Response to Comments, May 17 Email

Response to Comments, May 23 Email

1 Foodservice Equipment Plan
Q-101 SCALE: 1/4" = 1'-0"

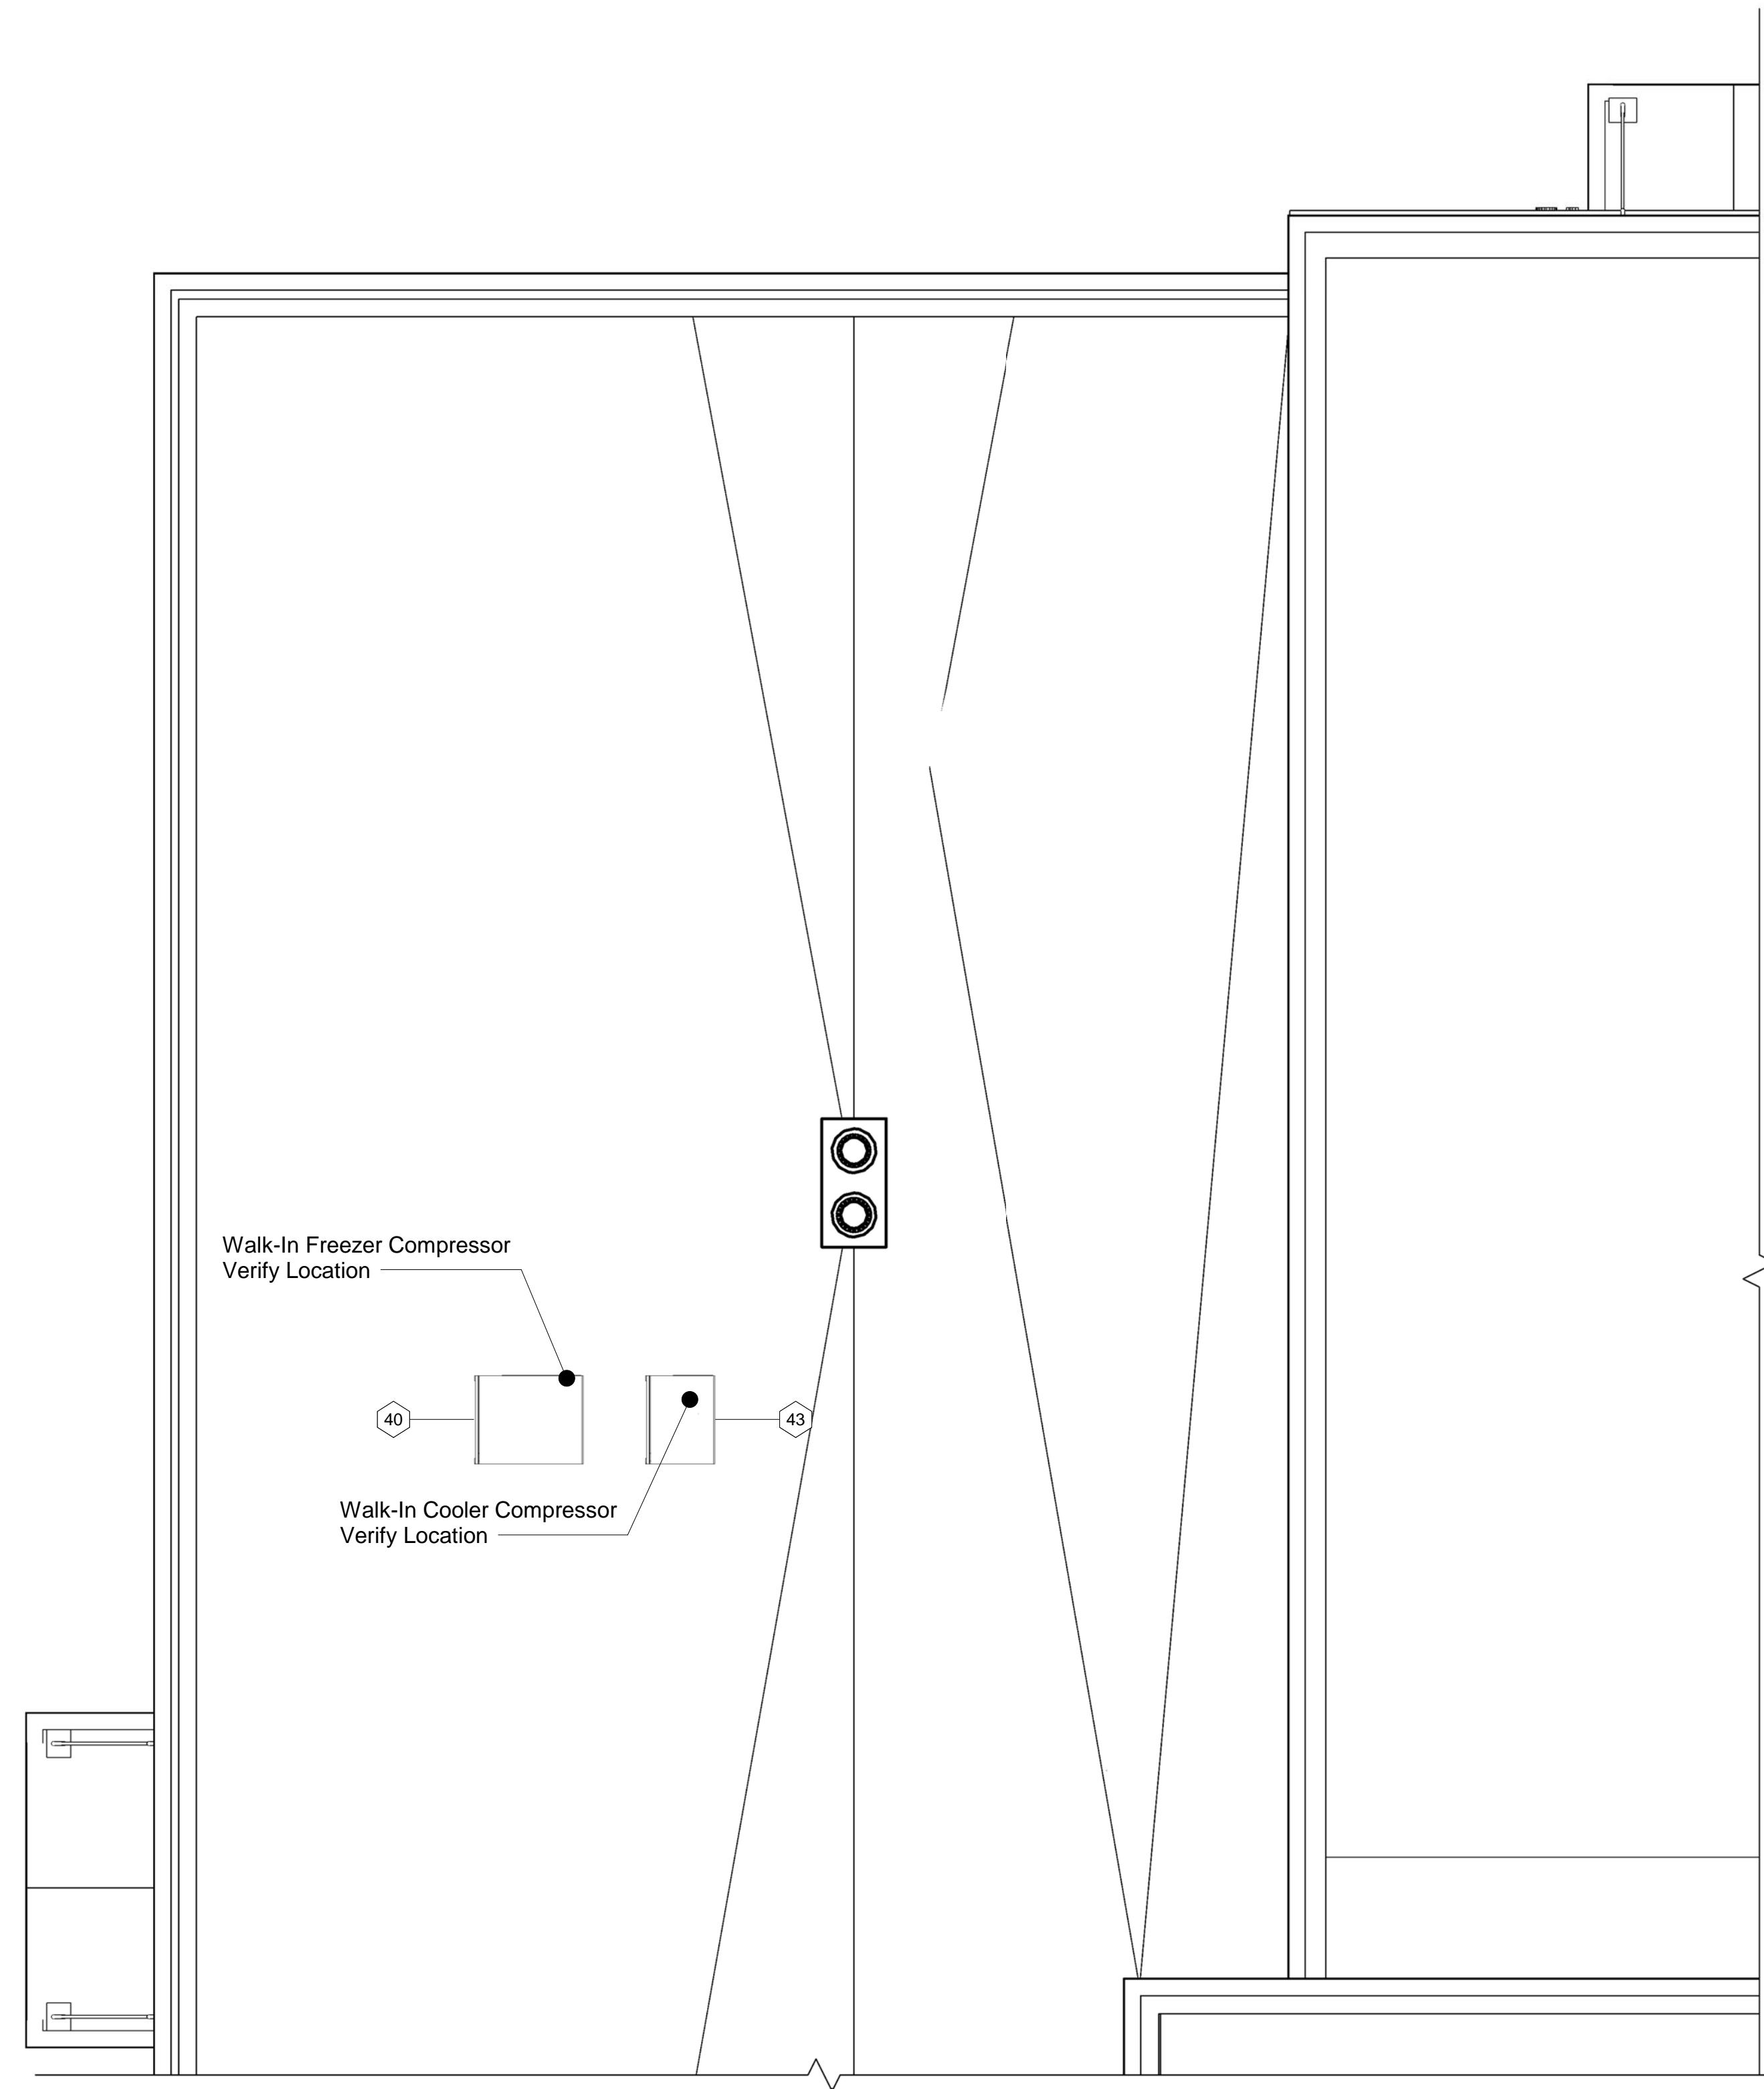
Q: Provide food service line with ADA accessibility requirements in cafeteria.

A: The food service drawings are on sheets Q-101 through Q115 in volume three of the documents.
